March 30, 2009

Re: 122 Pine Street – 062 B008 – R-6 – enclose porch & add deck – permit #09-0221

SITE PLAN : EXISTING

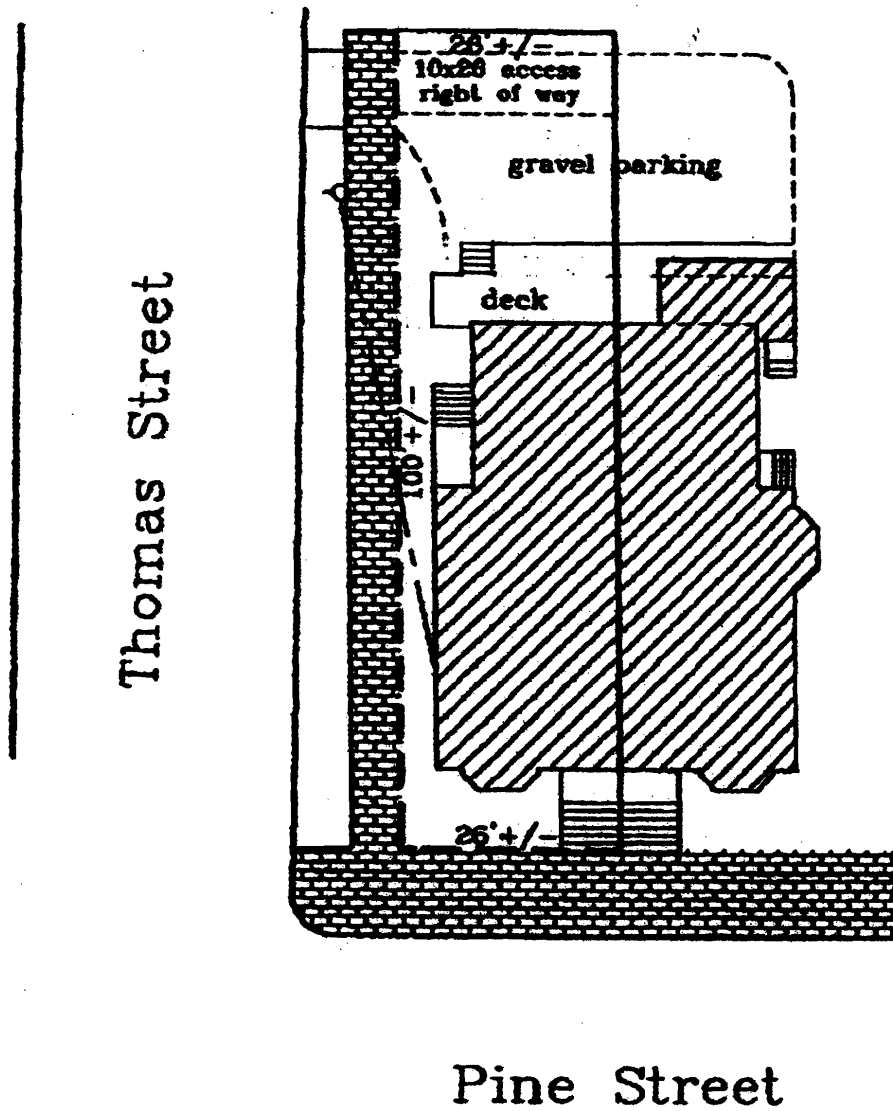
Your property is located in the R-6 zone. Section 14-139(1)(d)(4) of the ordinance gives the required side yard on a side street as ten feet. The proposed five foot by three foot ten inch deck addition is only five feet from the side property line on the side street.

The side porch and steps that you propose to enclose are also located five feet from the side property line on the side street. Section 14-427 of the ordinance allows a porch that encroaches on a yard setback to be enclosed with the majority of the enclosure being of glass, if the porch had a roof over it and it existed since June 5, 1957. The porch was built before June 5, 1957, but it does not have a roof over it, so it cannot be enclosed.

Section 14-139(1)(e) states that the maximum allowable lot coverage for a lot with less than twenty dwelling units is fifty percent. Your lot is 2,500 square feet, so the maximum allowable lot coverage is 1250 square feet. Currently without the addition, the existing footprint of your building is 1401 square feet (56%) which is already over the maximum allowable lot coverage. The deck addition would add 19.15 square feet which would bring the lot coverage to 56.8% of the lot.

In doing my research of the property, I could not find a permit for the 170 square foot rear deck. If we cannot find a permit for an addition in our files, we use the pre-1957 assessor's card to determine what the footprint of the building was before the ordinance went into effect in 1957. The pre-1957 assessor's card does not show a rear deck. There is only a five foot by four and a half foot landing shown. We also check the Sanborn Map from 1954. The footprint from this map does not show a rear deck. The rear deck puts the building over the allowable maximum lot coverage, and it does not

meet the required ten foot side setback. Since there is no record of a permit for the rear deck and it did not exist before 1957, it is illegal and must be removed.
